# CITY OF ALBUQUERQUE

September 27, 2012

**Re: Masthead Office Phase II  
Grading and Drainage Plan  
Engineer's Stamp dated 9-24-12 (D17/D003P1)**

Grading and Drainage Plan

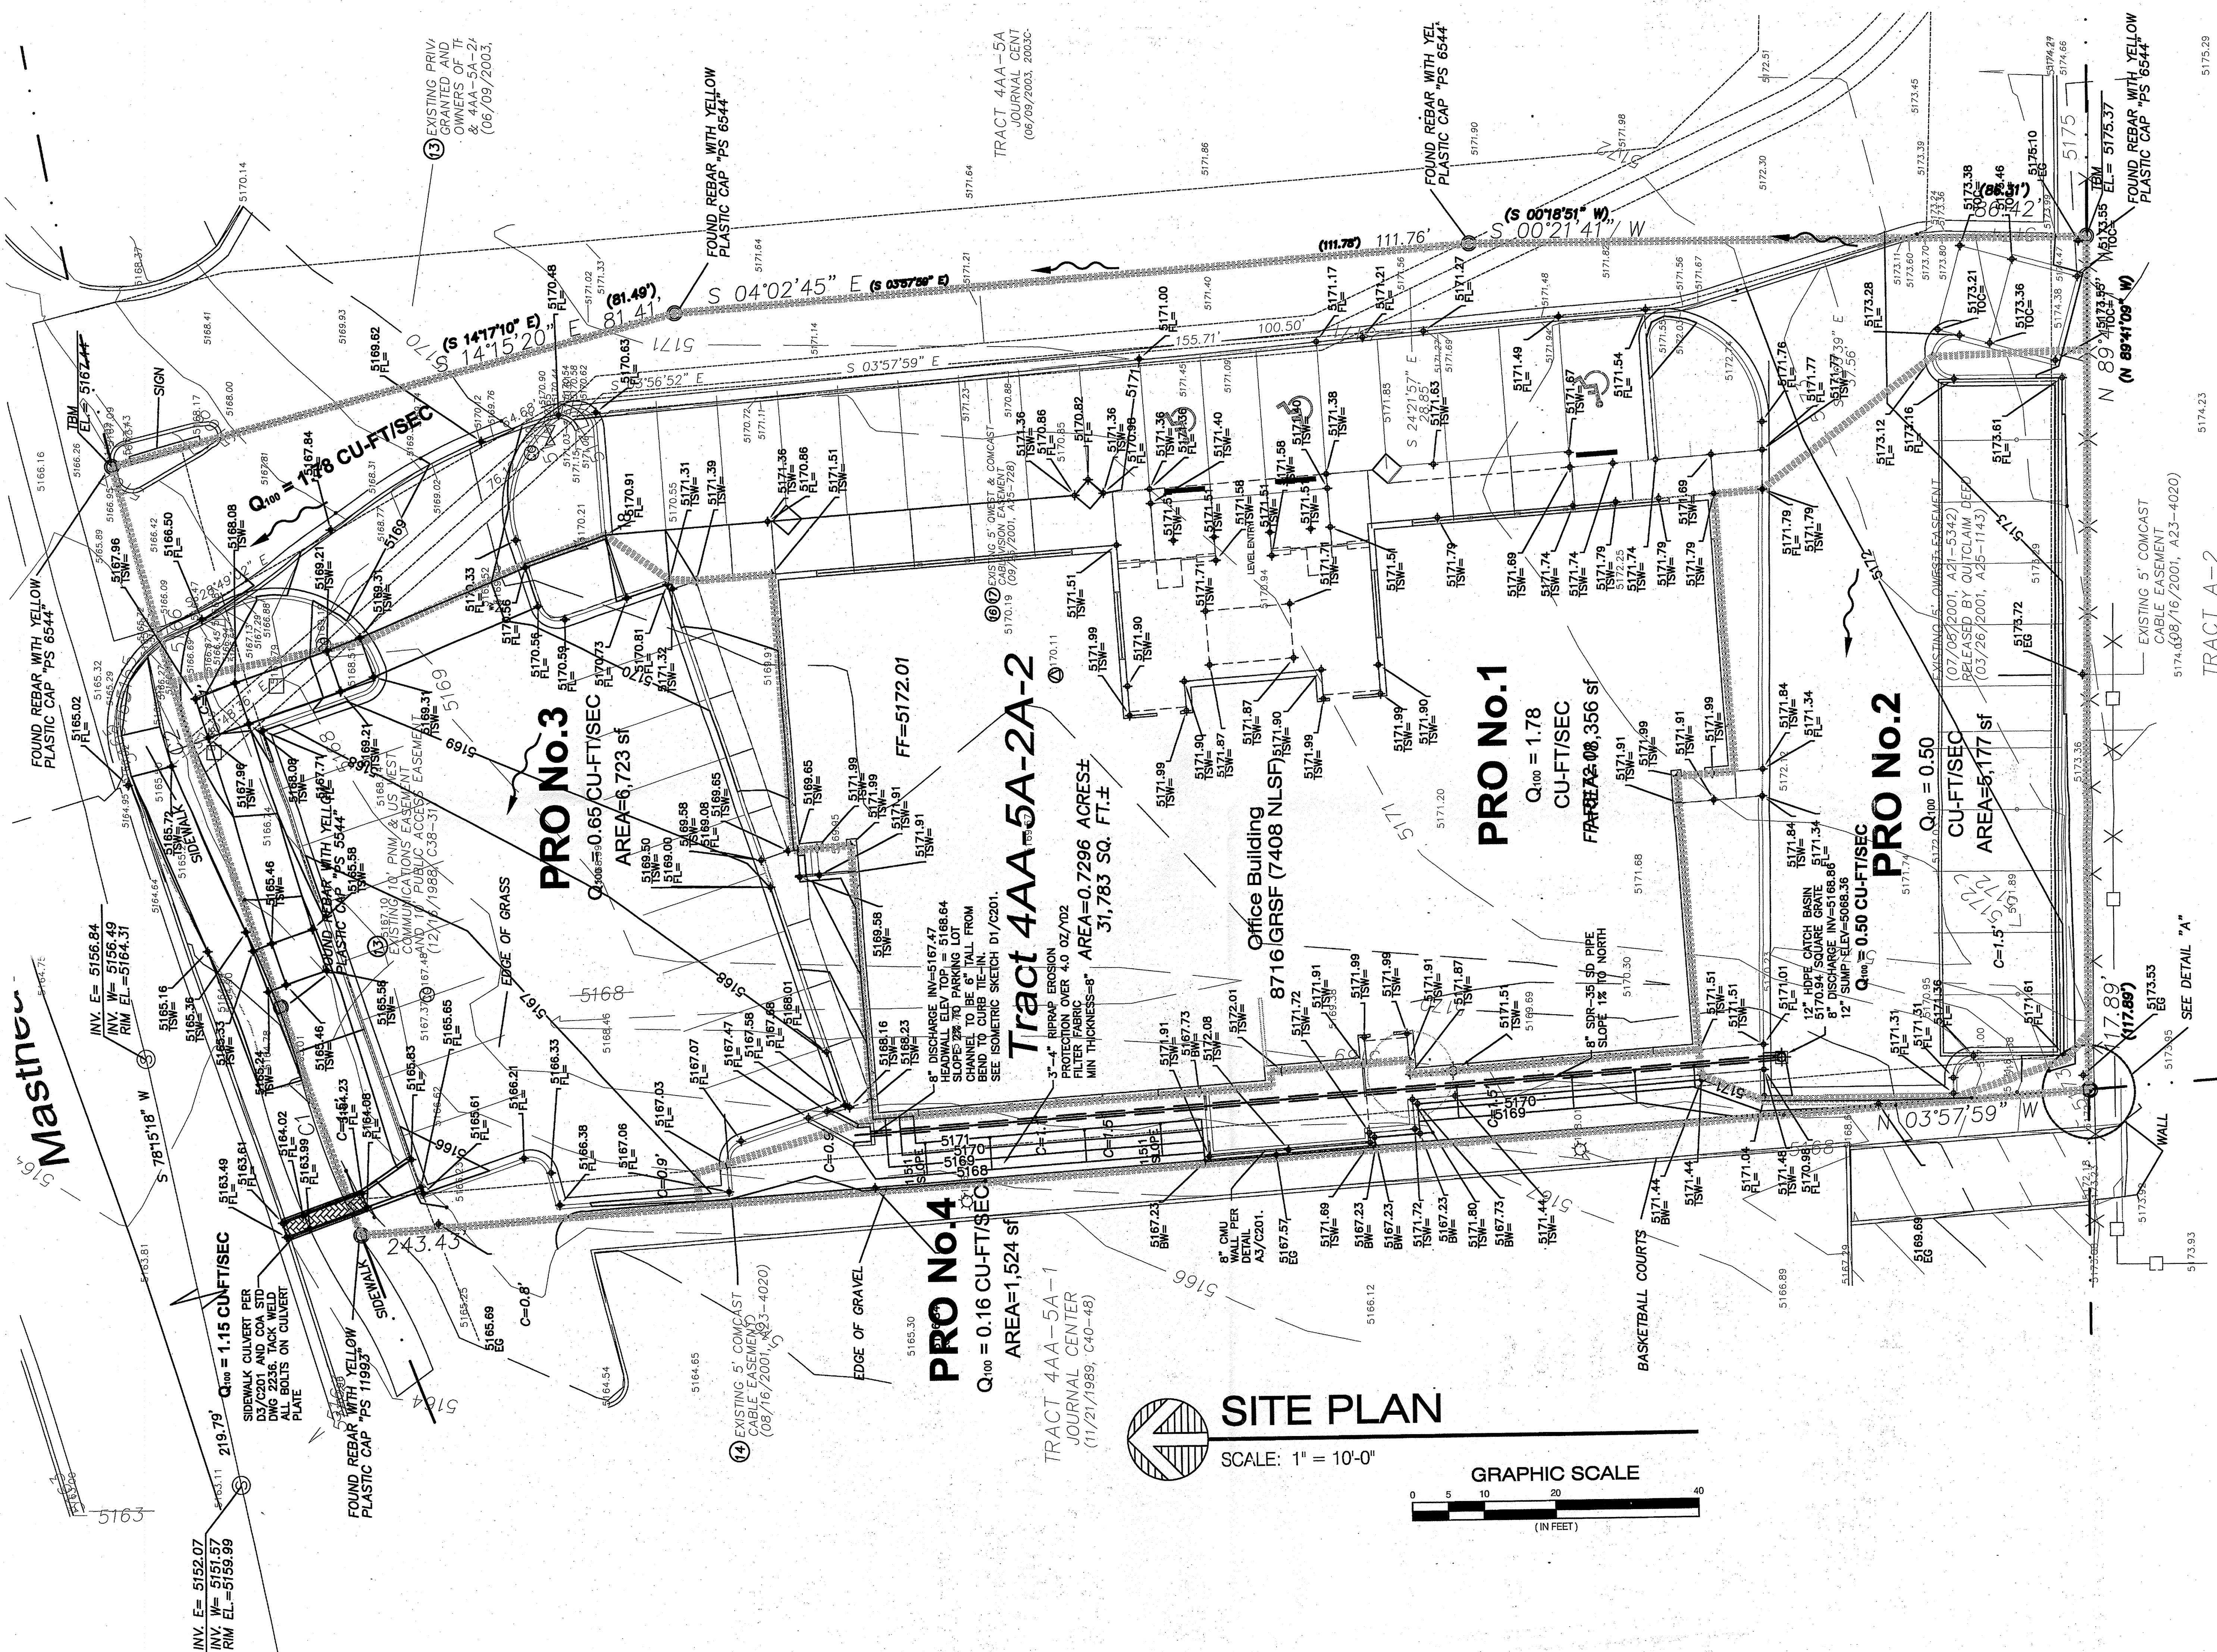
- Is there 3 or 4 drainage basins?
- The Drainage summary font is too small and not legible, increase the size and clarity.
- Under Prep 4 there is 105% land treatments.
- Site plan is not clear, enlarge.
- Depress all landscaping.
- Extend sidewalk culvert plate 2 feet past the property line.
- Tack weld all bolts on the sidewalk culvert plate.
- Show spot elevations along the property lines.
